Date: 09 November 2022  
Our ref: Boston Alternative Energy Facility  
Your ref: EN010095

### **NSIP Reference Name: Boston Alternative Energy Facility (BAEF)**

Natural England's answers to the Secretary of State's further questions as requested on 14<sup>th</sup> October 2022 are as follows;

TITLE  
 BOSTON ALTERNATIVE ENERGY FACILITY  
 DEVELOPMENT CONSENT ORDER  
 Regulation 5(2)(c) - Illustrative Landscape Plans  
 BOSTON BOROUGH COUNCIL  
 SHEET 8 OF 8

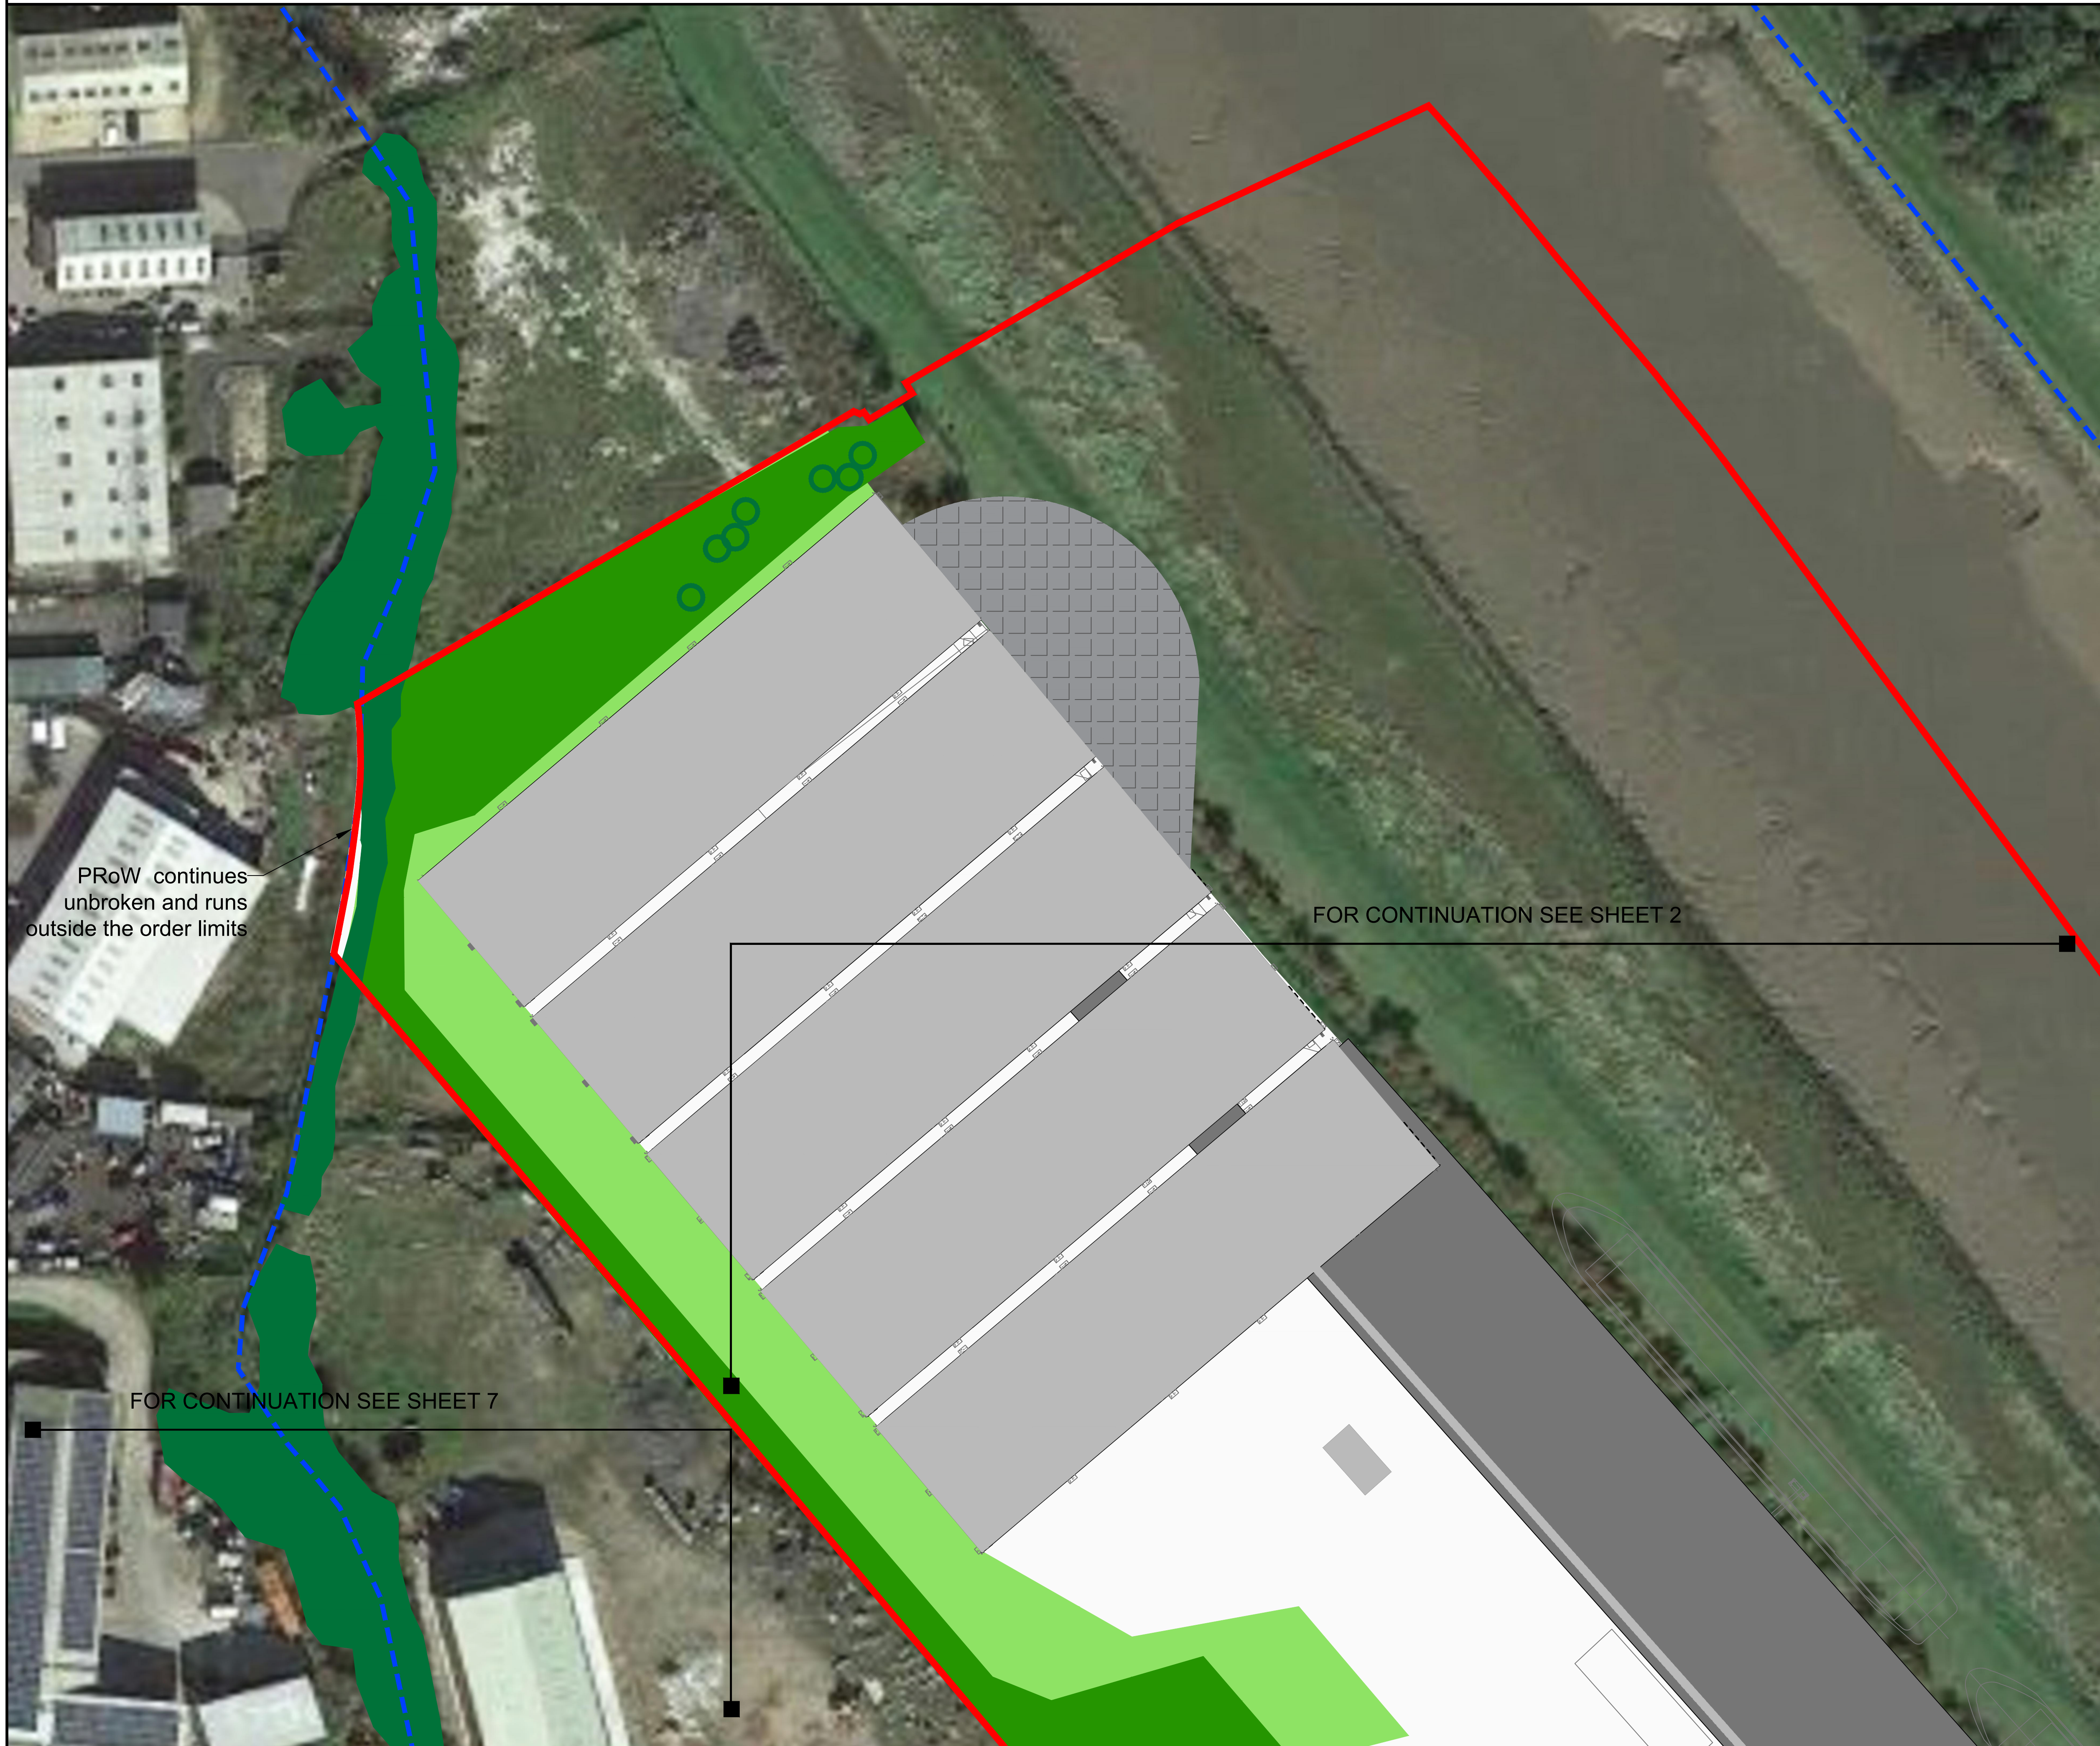
We advise that this position remains unchanged and that more detail in the form of a site specific plan is still required to demonstrate that the mitigation/compensation will be sufficient to offset the impacts to Annex I birds

In addition we highlight that much of our advice and queries raised within our detailed comments table provided in Appendix B5 at Deadline 8 [REP8-23] remain unaddressed by the Applicant including points 8, 12 and 13 relating specifically to the mitigation area.

We also reiterate that the functional linked land is also priority habitat and concerns raised by Natural England throughout the examination on impacts to this habitat have not be mitigated for either.
